**Land at Bilsham Road, Yapton**  
**Planning Reference: Y/70/22/DOC**

**Approval of details reserved by condition imposed under ref Y/91/17/OUT relating to Condition Nos 9 - surface water drainage and 27 relating to levels.**

**At this stage we would recommend that this condition is not discharged at this time until further information is provided and the comments below are addressed**

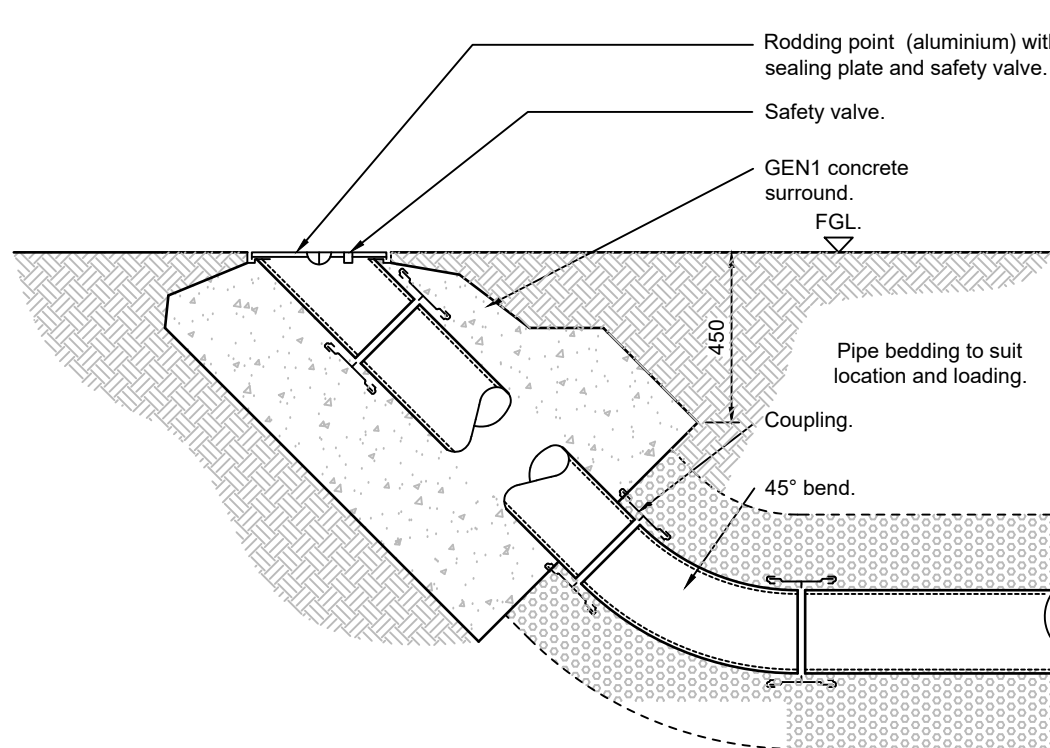
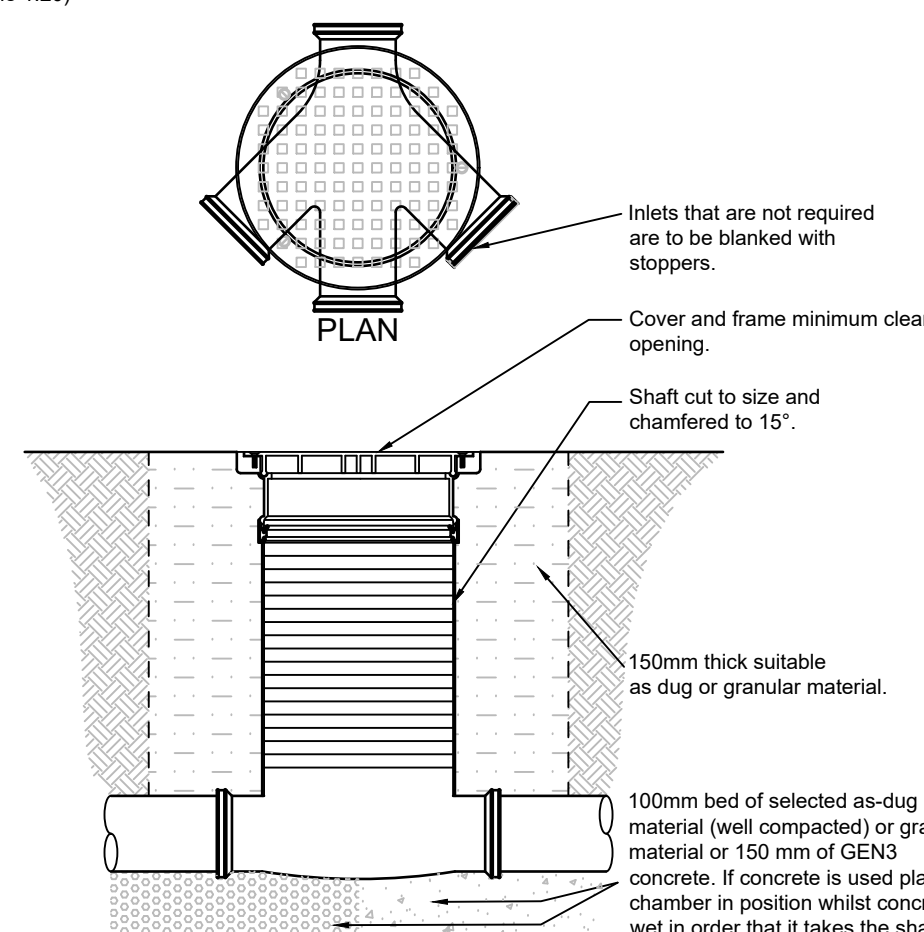
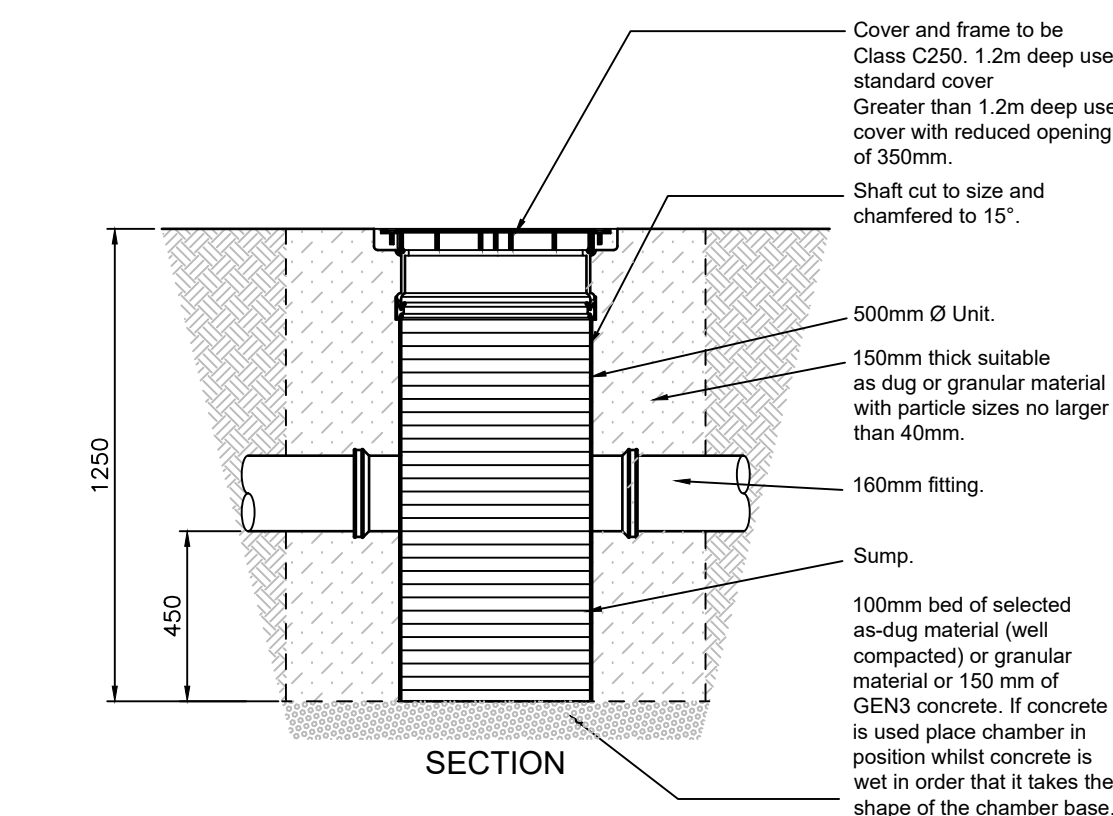
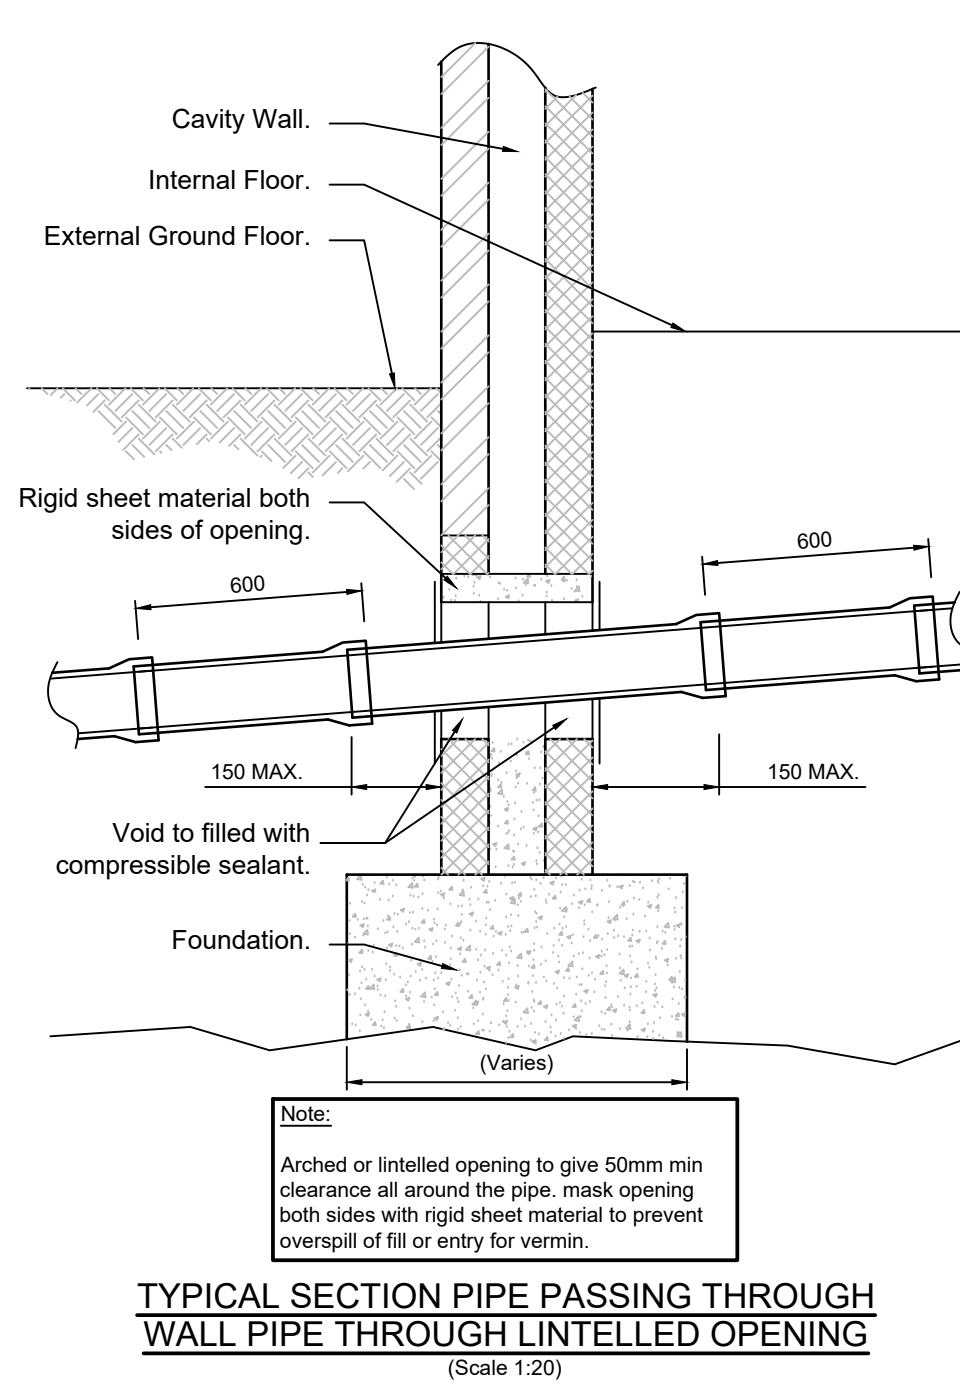
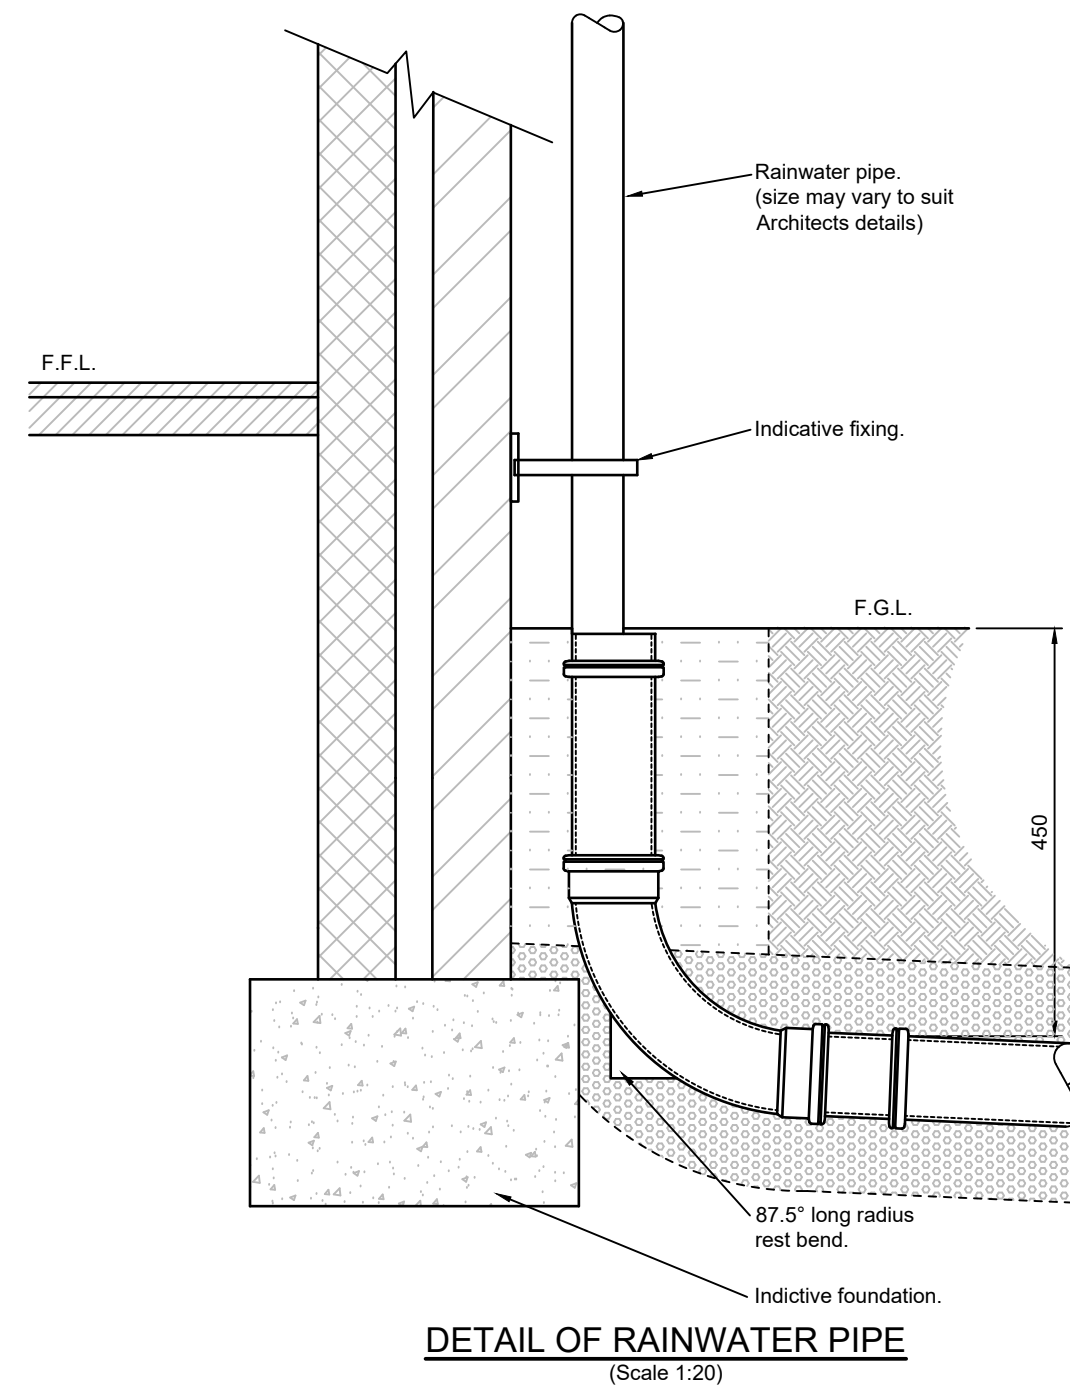
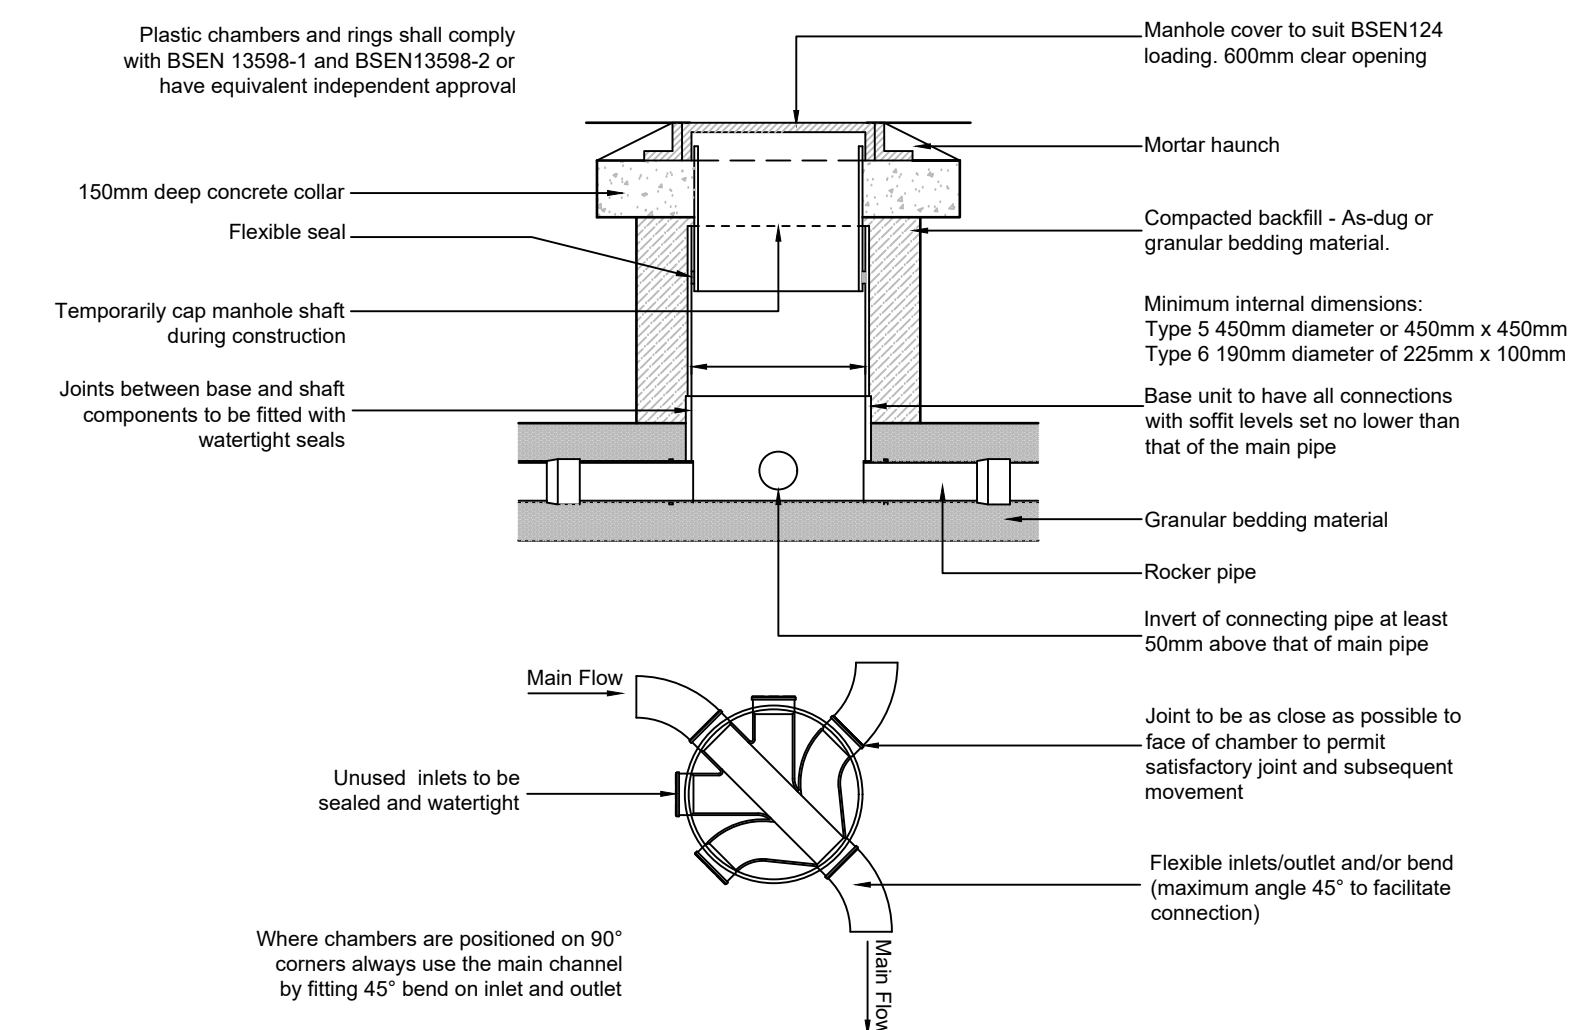
16. *Please provide a construction detail of permeable paving which clearly defines the construction, i.e. blocks, bedding, membranes, sub-base, tanking membrane. Materials and depths should be clearly defined. The construction detail shown on drawing D1956-15.2 conflicts with that shown on D1956-15-3A. These need to be updated to ensure there is no conflicting information. In addition to this its not clear why part infiltration has not been sought in areas where the infiltration has demonstrated that this is achievable. The applicant should clarify clear reasons as to why infiltration techniques have not been used for the permeable paving in the areas within the vicinity of the following test locations: TP05; TP04; TP01. 08/2/2023- This has now been received and we have no further comments.*
